# Permit Reviews Harnett County

**Permit Number: SFD2110-0124**

Description: **82x78**

Site Address: **1121 D L PHILLIPS LN**

PROJECT: **HOFFNER JOB**
 CUSTOMER: **FREEDOM CONSTRUCTION**
 MODEL: **HOFFNER**
 QUOTE #: **2200084** PRINT DATE: **2/9/2022** SCALE: **N.T.S**
 DRAWN BY: **Rodney Evans**

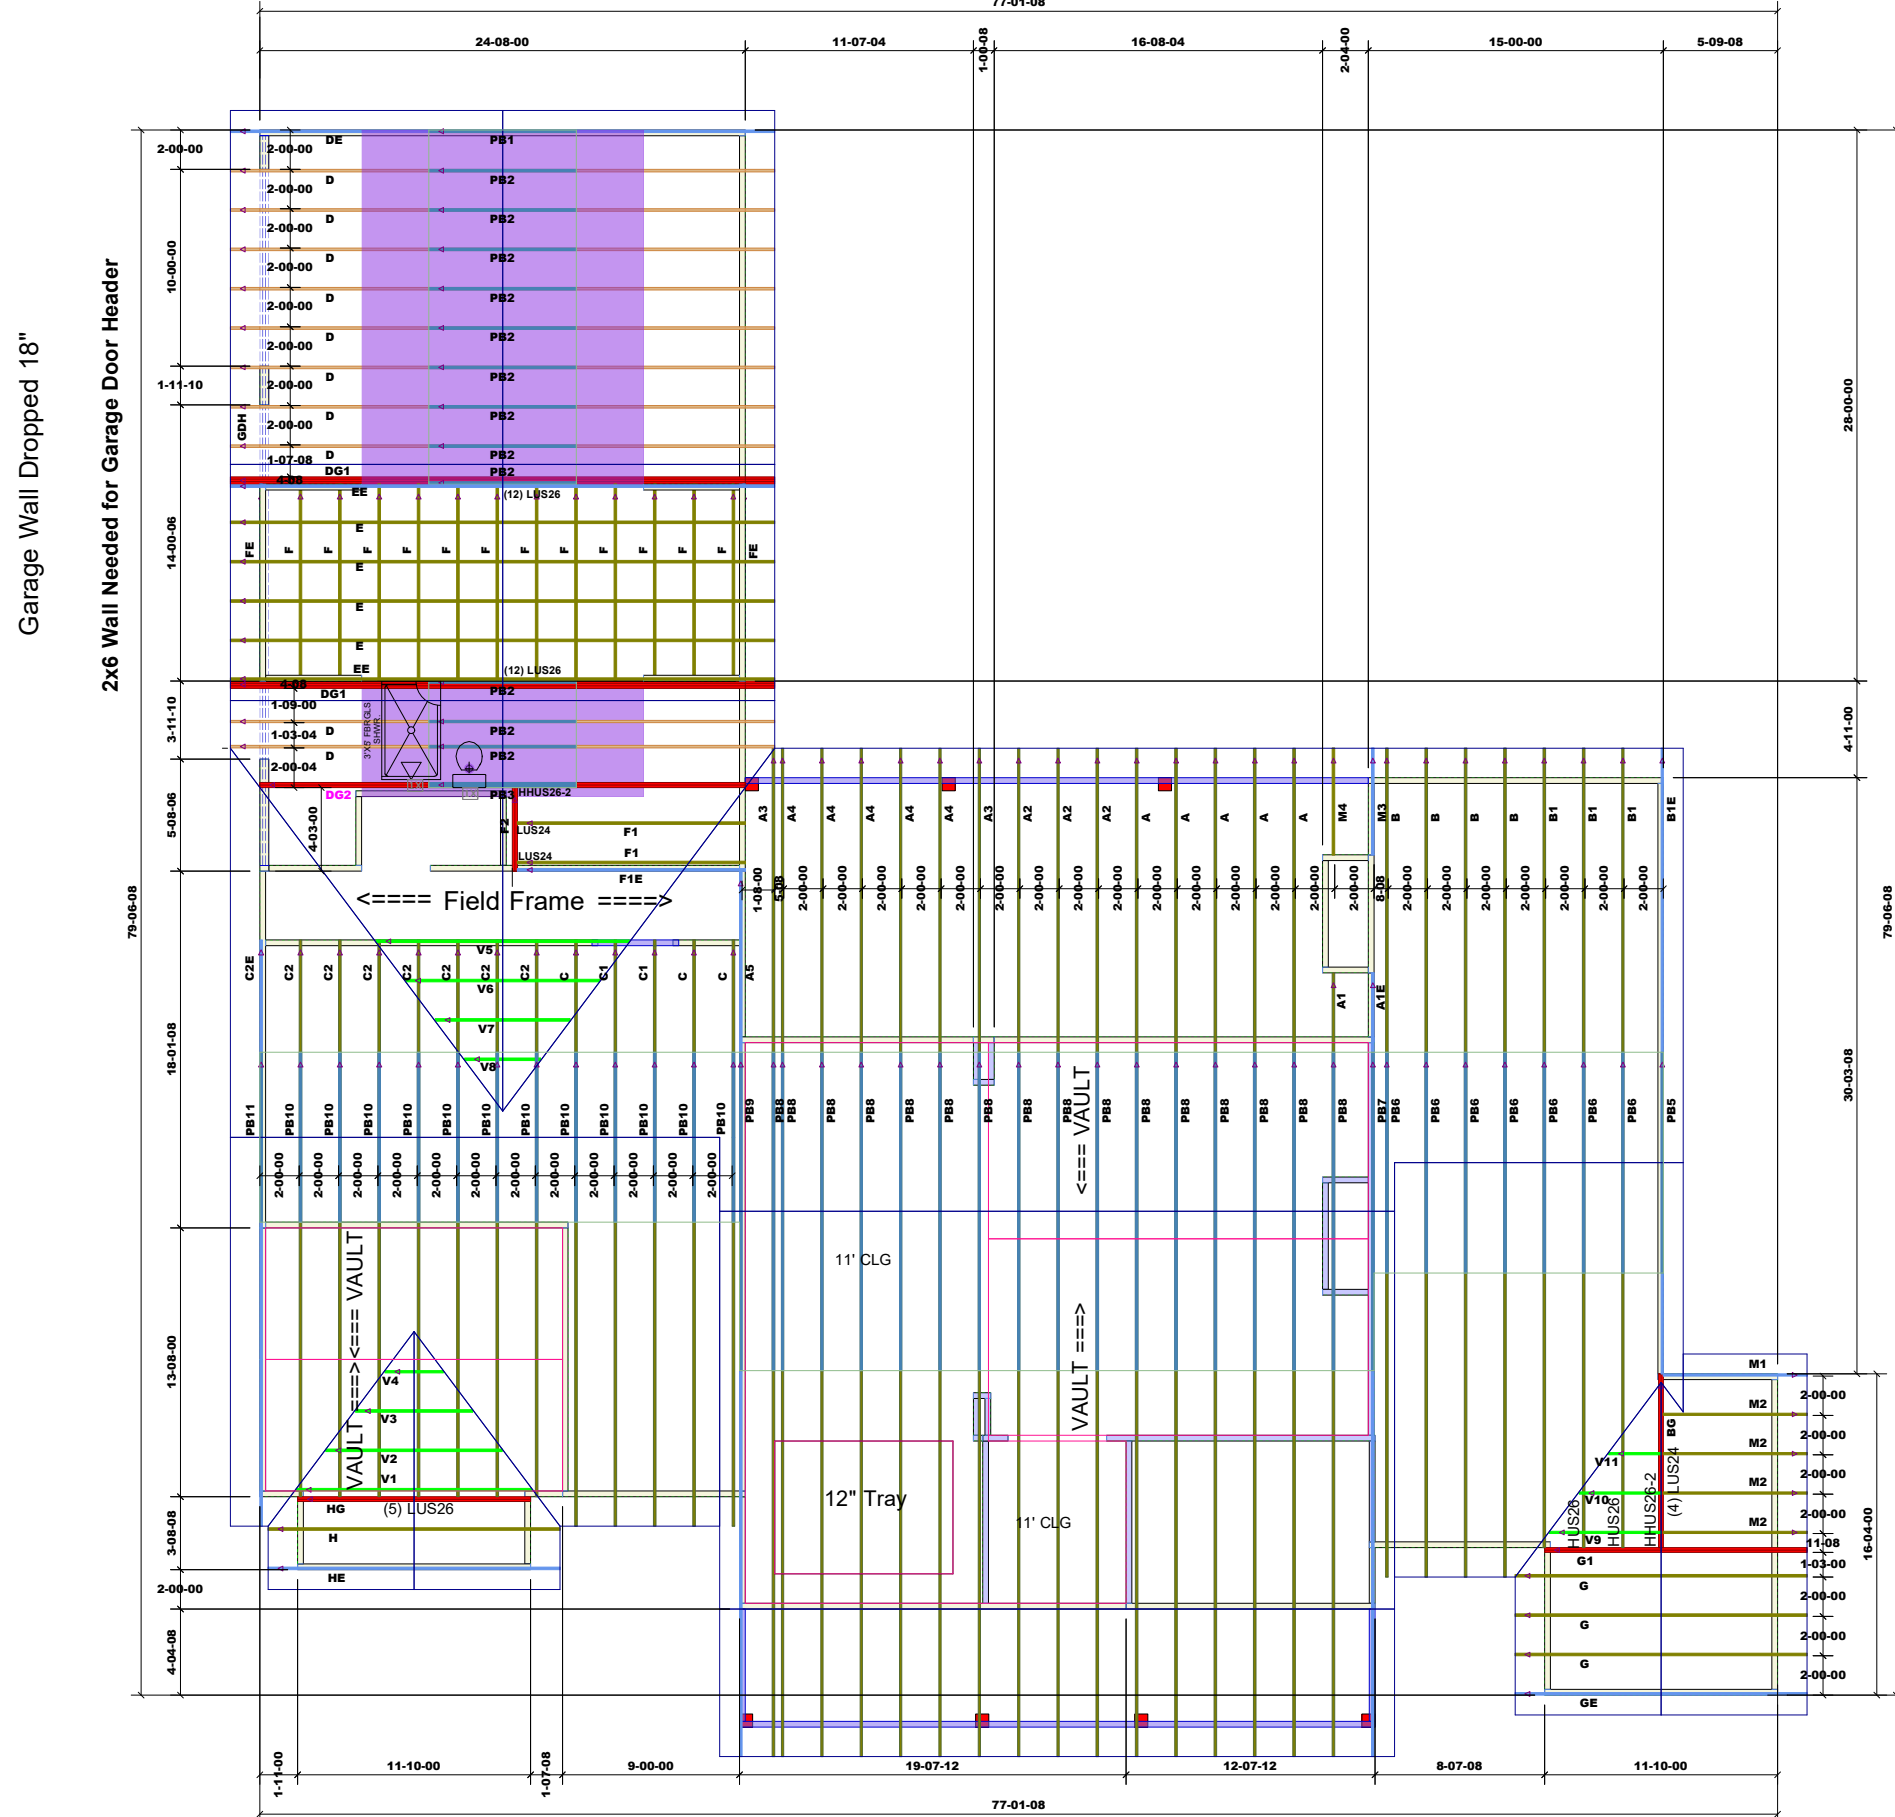
SENT DATE	RETURNED DATE	DUE DATE	TYPE	CONTACT	STATUS	REMARKS
Review Group: 2ND PLAN REVIEW						
2/22/2022	3/2/2022	2/25/2022	RESIDENTIAL BUILDING	Brad Sutton	DISAPPROVED	
Notes: see new plans Need truss and beam info						
Review Group: ALL						
10/29/2021	11/16/2021	11/15/2021	Environmental Well	MARK OSBORNE	APPROVED	
Notes:						
2/16/2022	2/22/2022	3/2/2022	ENVIRONMENTAL	MARK OSBORNE	APPROVED	
Notes: Please update with correct address of 1121 D L Phillips, address was created after approval						
2/16/2022	2/22/2022	3/2/2022	Environmental Well	MARK OSBORNE	APPROVED	
Notes: Please update with correct address of 1121 D L Phillips, address was created after approval						
Review Group: AUTO						
10/29/2021	11/16/2021	11/15/2021	ENVIRONMENTAL	MARK OSBORNE	APPROVED	
Notes:

10/29/2021	3/8/2022		SFD INTAKE	CP Bucket	APPROVED	
Notes:						
10/29/2021	11/4/2021	11/3/2021	RESIDENTIAL BUILDING	Brad Sutton	DISAPPROVED	
Notes: Need all calculation sheets for beams. Need I joist info and layout from supplier. Need a roof layout for roof over garage. If roof is to be trusses instead of stick frame, supply roof truss layouts. All ceiling joists and rafters shall be designed to the span charts in the 2018 NCRC, with limited storage over ceiling joists.						
2/16/2022	2/21/2022	2/21/2022	RESIDENTIAL BUILDING	Brad Sutton	APPROVED	
Notes:						
3/2/2022	3/4/2022	3/4/2022	RESIDENTIAL BUILDING	Brad Sutton	APPROVED	
Notes:
